WA:2544_8.109_PSC cover letter
Monday, 4 March 2019

**Re: SSD 8989 Catherine McAuley Catholic College, Medowie
Additional Information Requested to support Development Application**

Design Meeting Minutes

P0925 CMCC Access Design Analysis

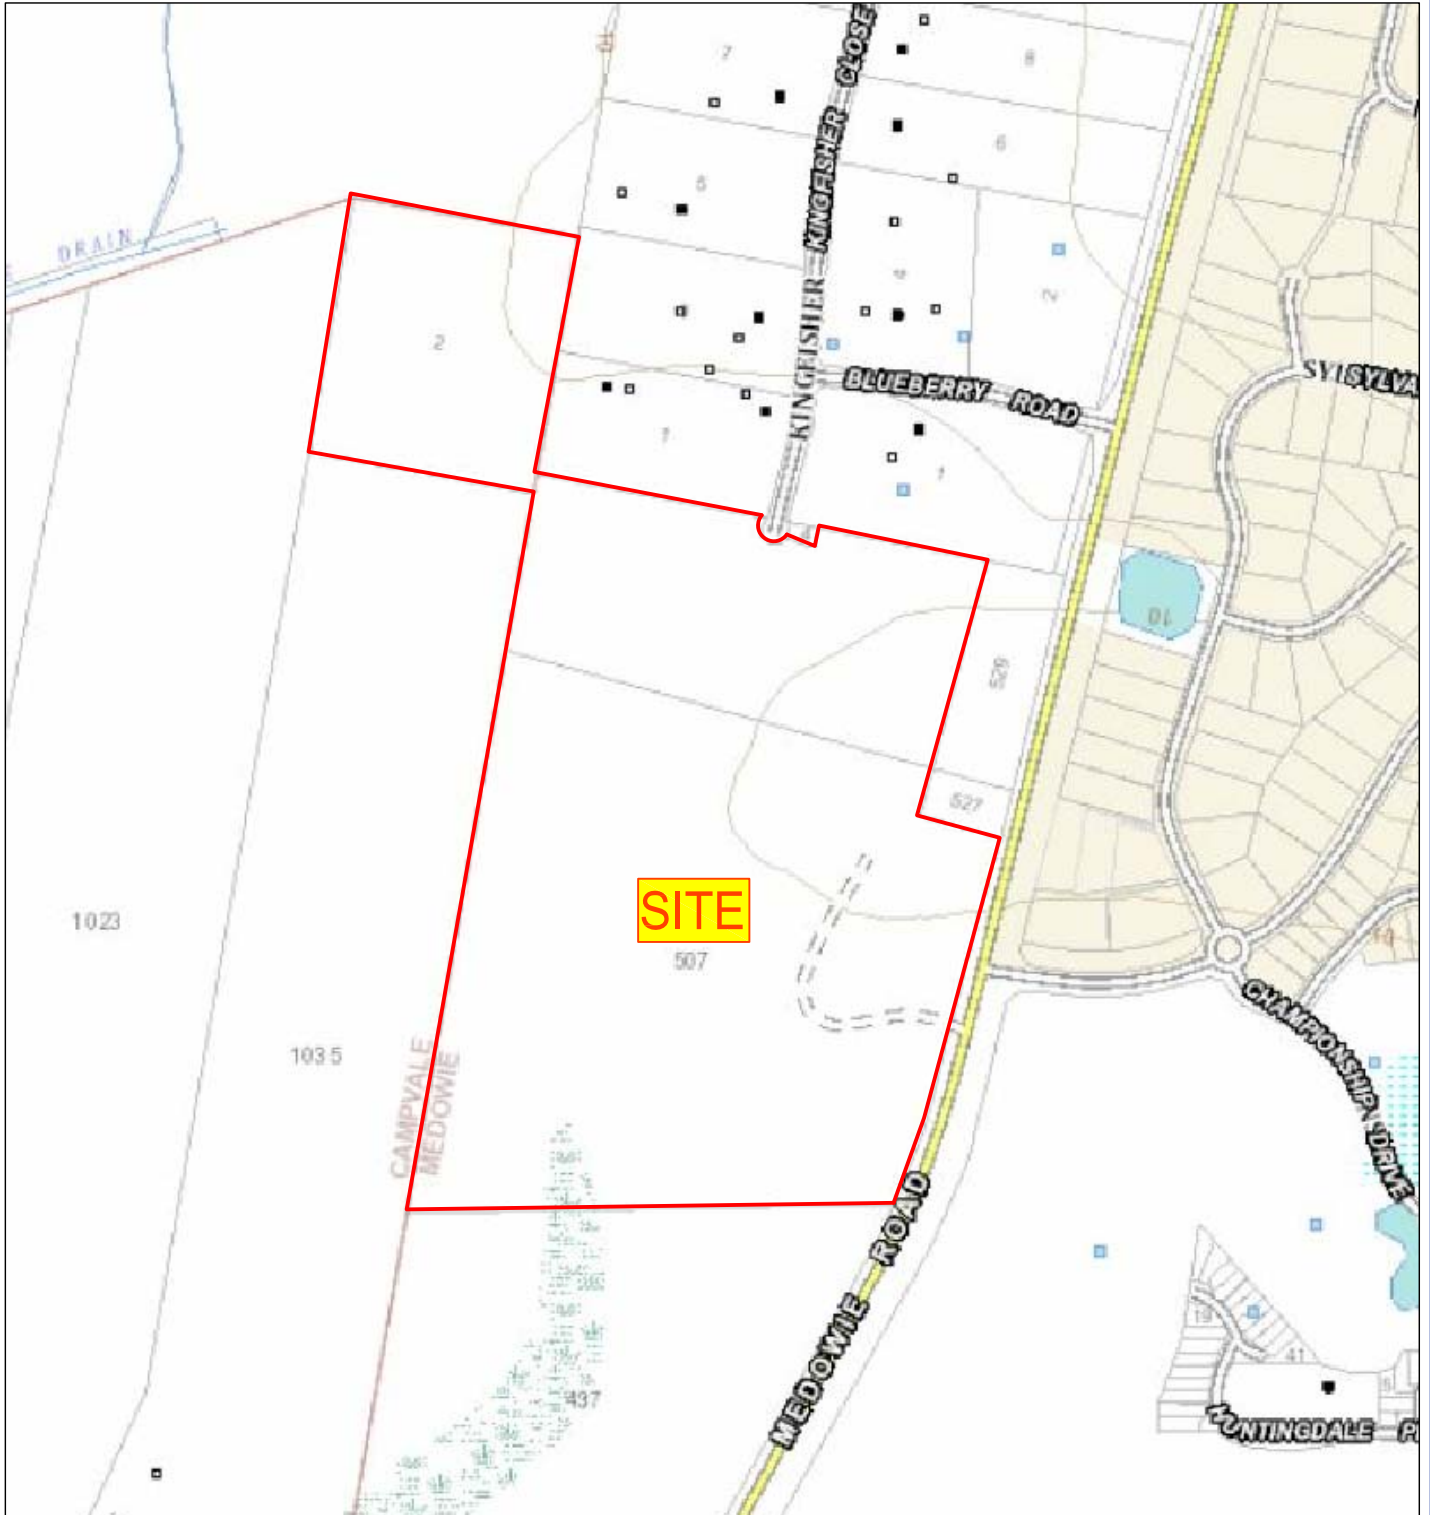
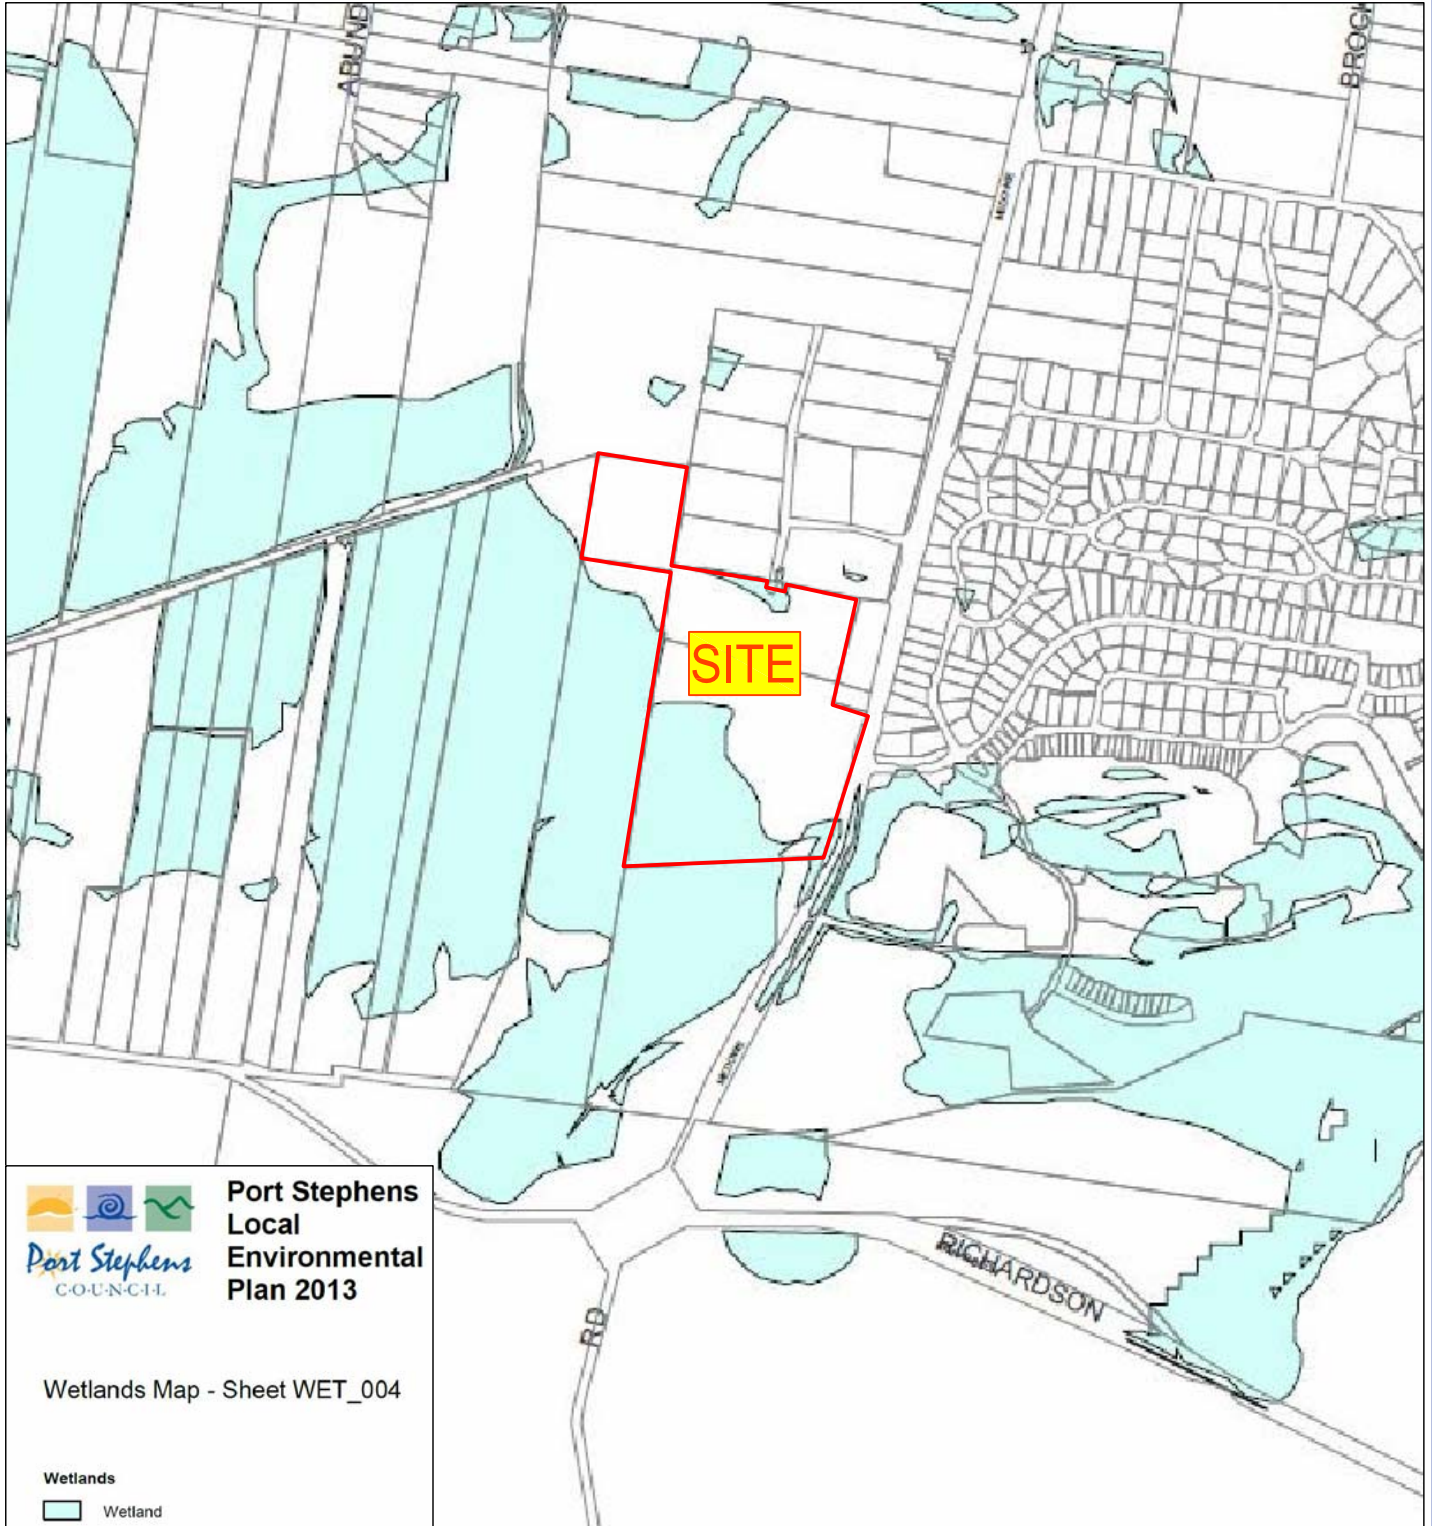
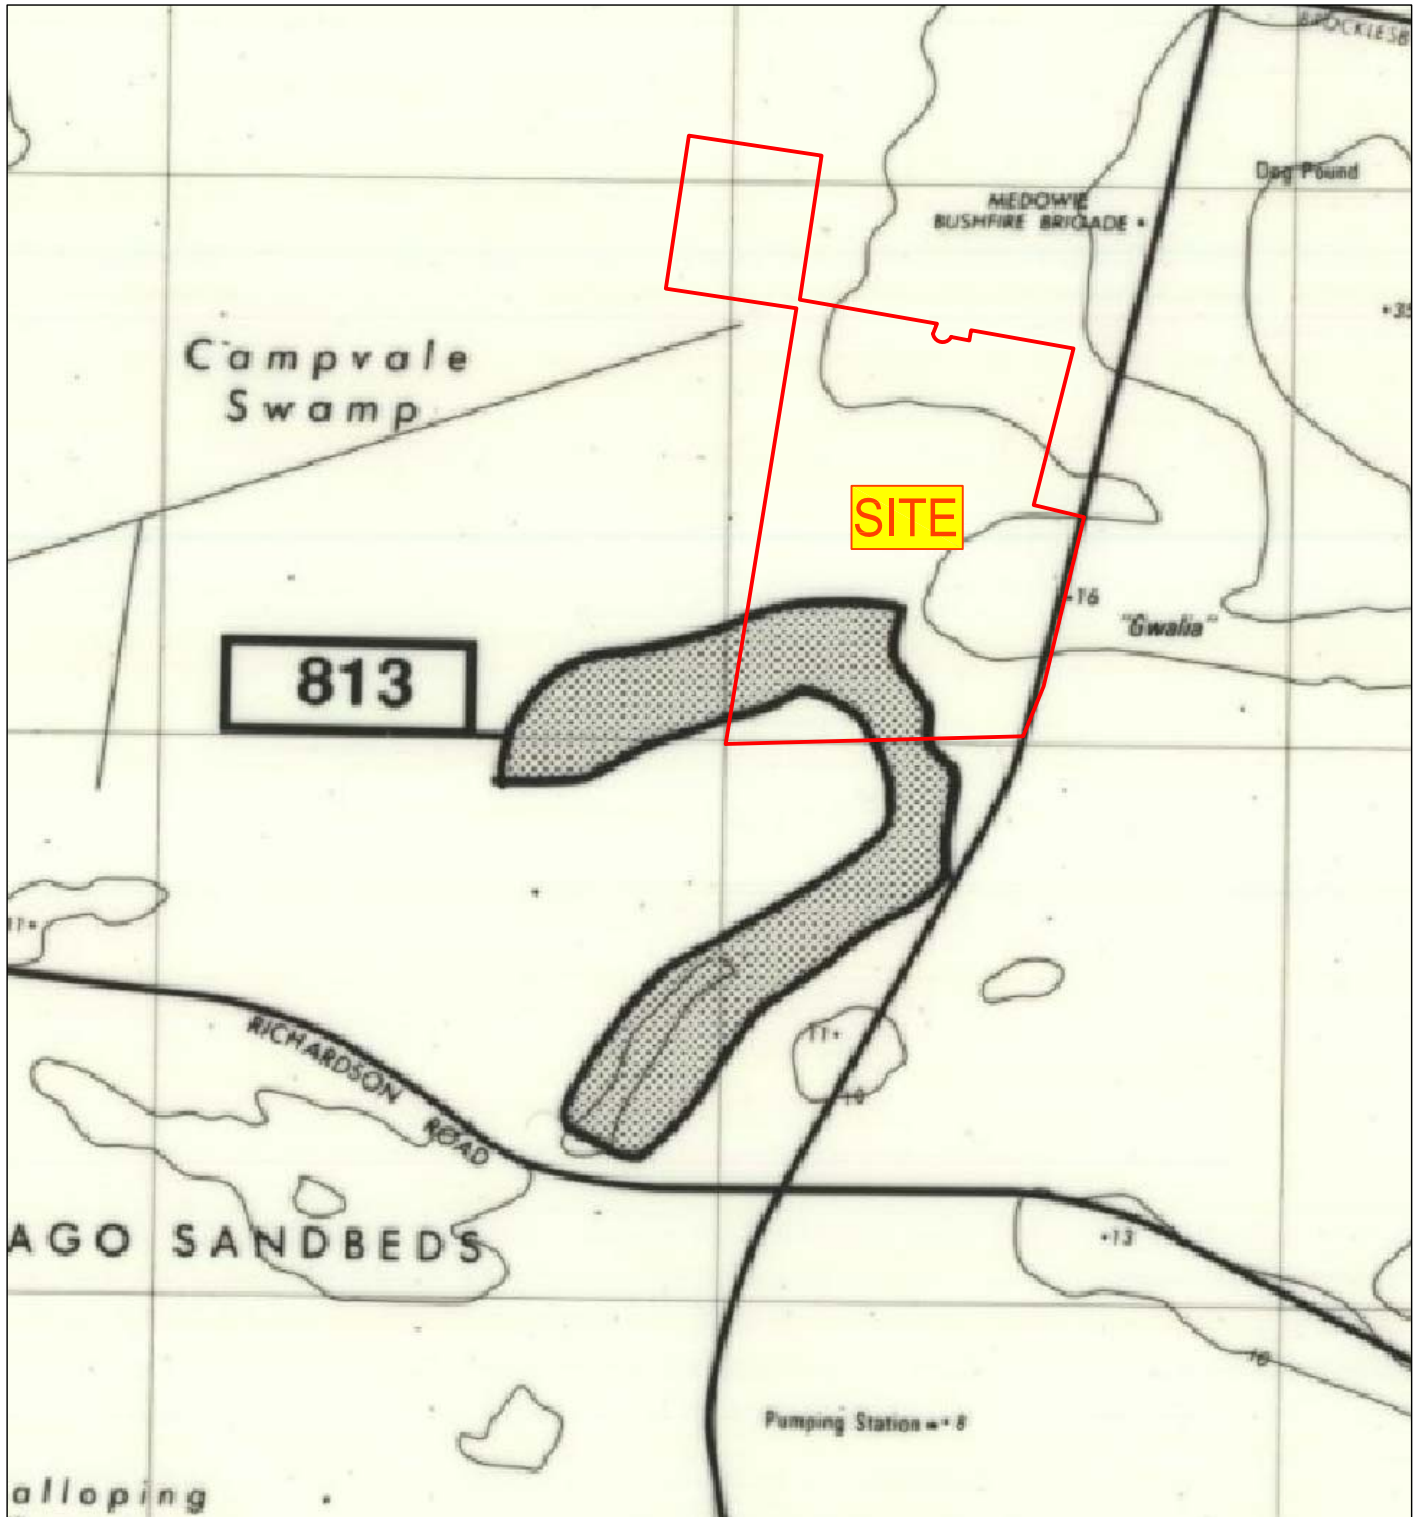
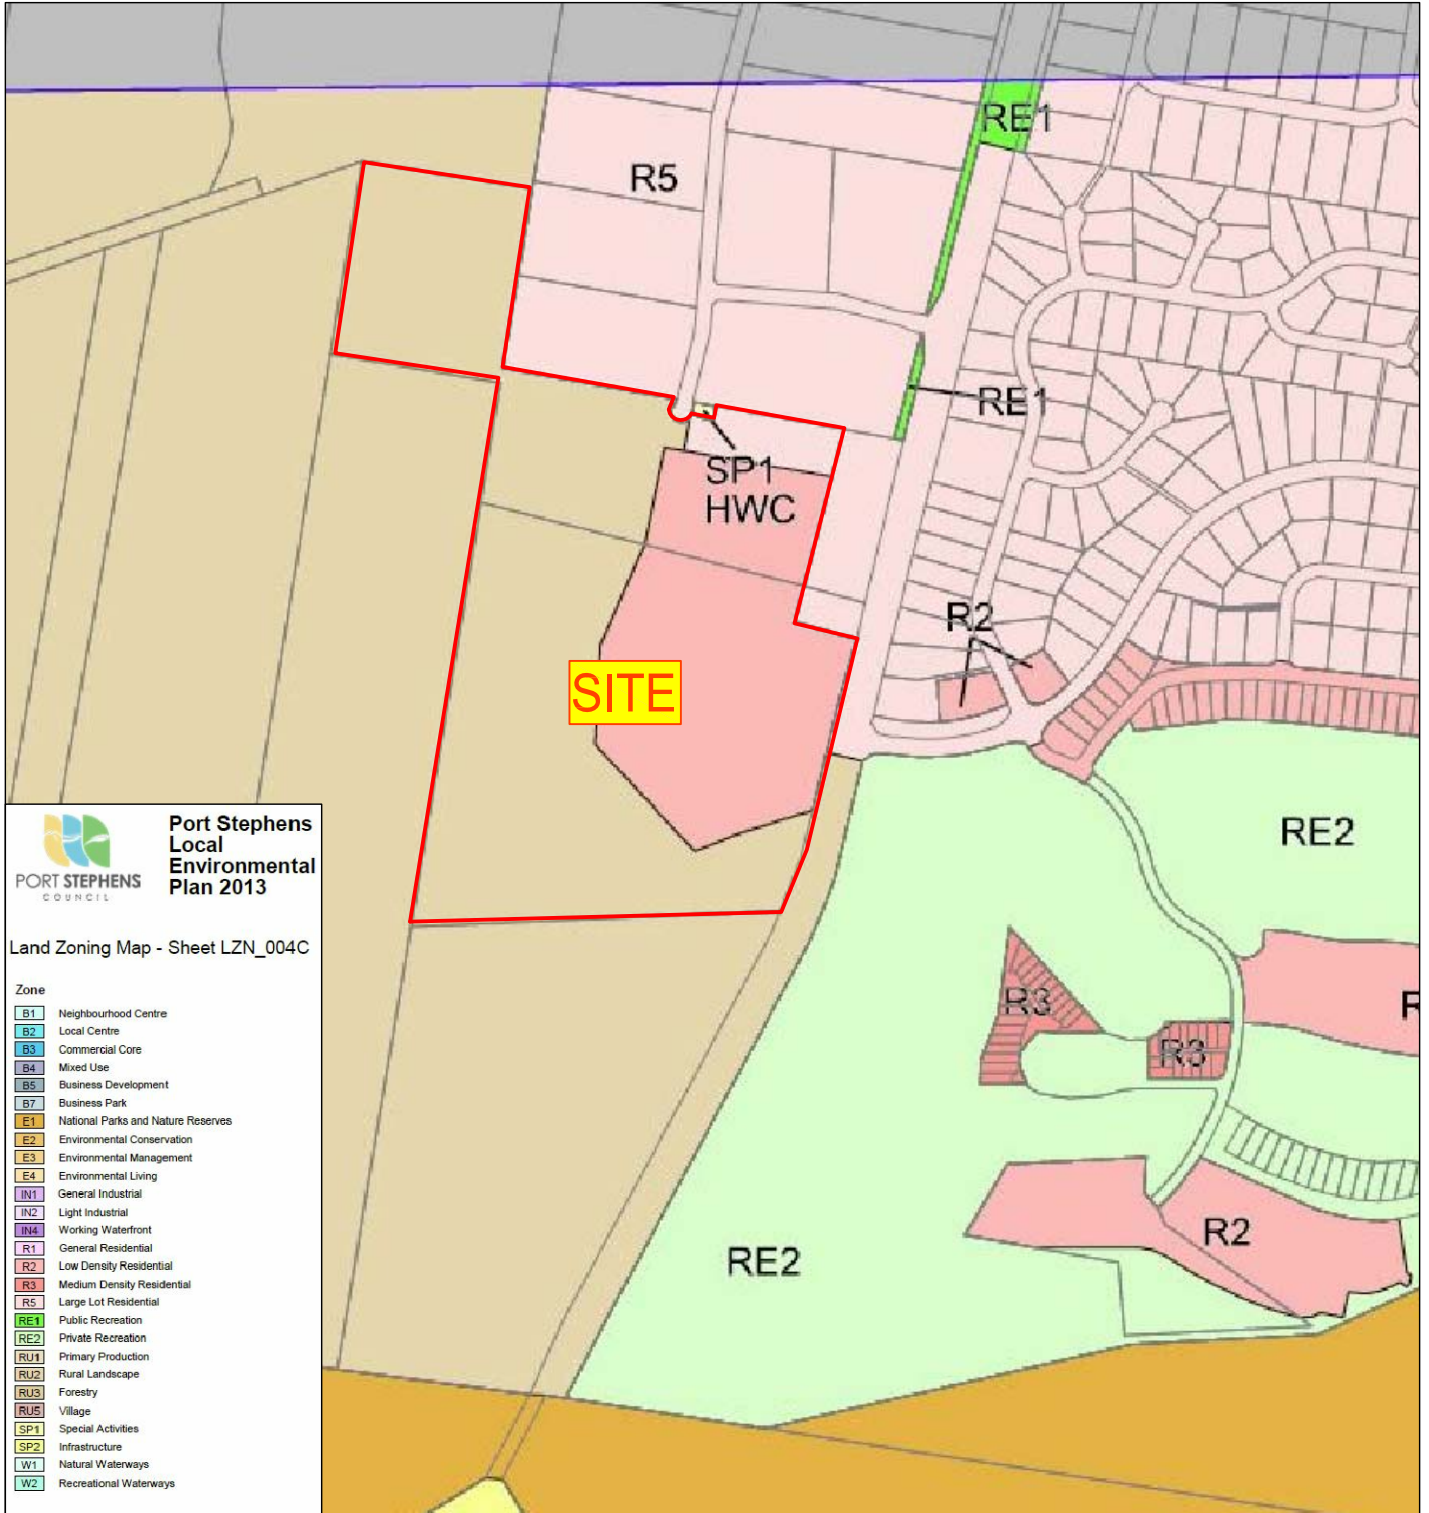
23.	JB queried why the culvert crossing under the roadway was square to the road and not tapered with the creekline to facilitate hydraulic flow. TH to request a response from the civil designer.	Webber Architects

The Civil engineer has advised the culvert shown on the concept civil roadway drawings follows the line of the existing culvert and creek bank. An extract of the site survey in this area is enclosed for reference.
